Rezoning Transportation Analysis

Petition Number: Insert Zoning Petition #2021-036

General Location Identifier: Tax ID 06306125

Date	Description
04-29-21	First Review (EL)
05-27-21	Second Review (EL)
06-24-21	Third Review (EL)

RZ-1

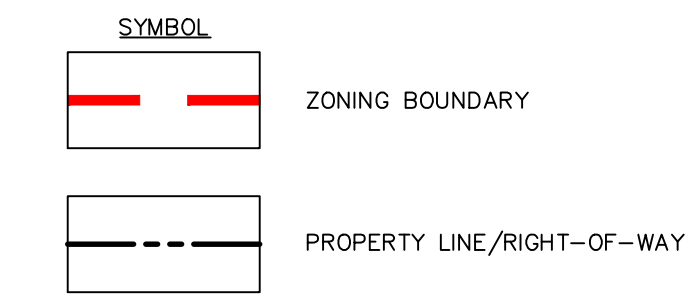
- ~~1. **Curbline:** The proposed zoning district has a setback measured from back of the existing or proposed future curbline.~~
 - ~~a. **South Hoskins Road:** The future location of curb and gutter is 27.5 feet from road centerline. While the existing curb and gutter may remain in place, show the future curbline location for reference.~~

- ~~b. **Gossett Avenue:** The future location of curb and gutter is in its existing location.~~

~~Label and dimension the curb and gutter from the centerline for each road on the site plan.~~

- ~~3. **Update to comment (site plan dated 05.17.21):** meander the sidewalk to preserve existing trees. Sidewalk may be contained within a sidewalk utility easement 2 feet from proposed back of sidewalk, where located outside of the public right-of-way. Revise the site plan and conditional note(s) to commit to construct an 8 foot planting strip and 6 foot sidewalk on South Hoskins Road, labeled and dimensioned from the road centerline and future curb line location, in support of the Charlotte WALKS Council adopted policy. Replace the existing accessible ramp at the intersection with two standard CLDSM PROWAG directional ramps.~~

- 4. ~~Site plan and conditional note(s) revisions are needed to dedicate and dimension 43.5 feet of right-of-way from the South Hoskins Road centerline, to accommodate the future cross section that accommodates a buffered bike lane facility per the Charlotte BIKES Council adopted policy.~~
- 5. ~~Site plan and conditional note(s) revisions are needed to correct the driveway call-out below.~~
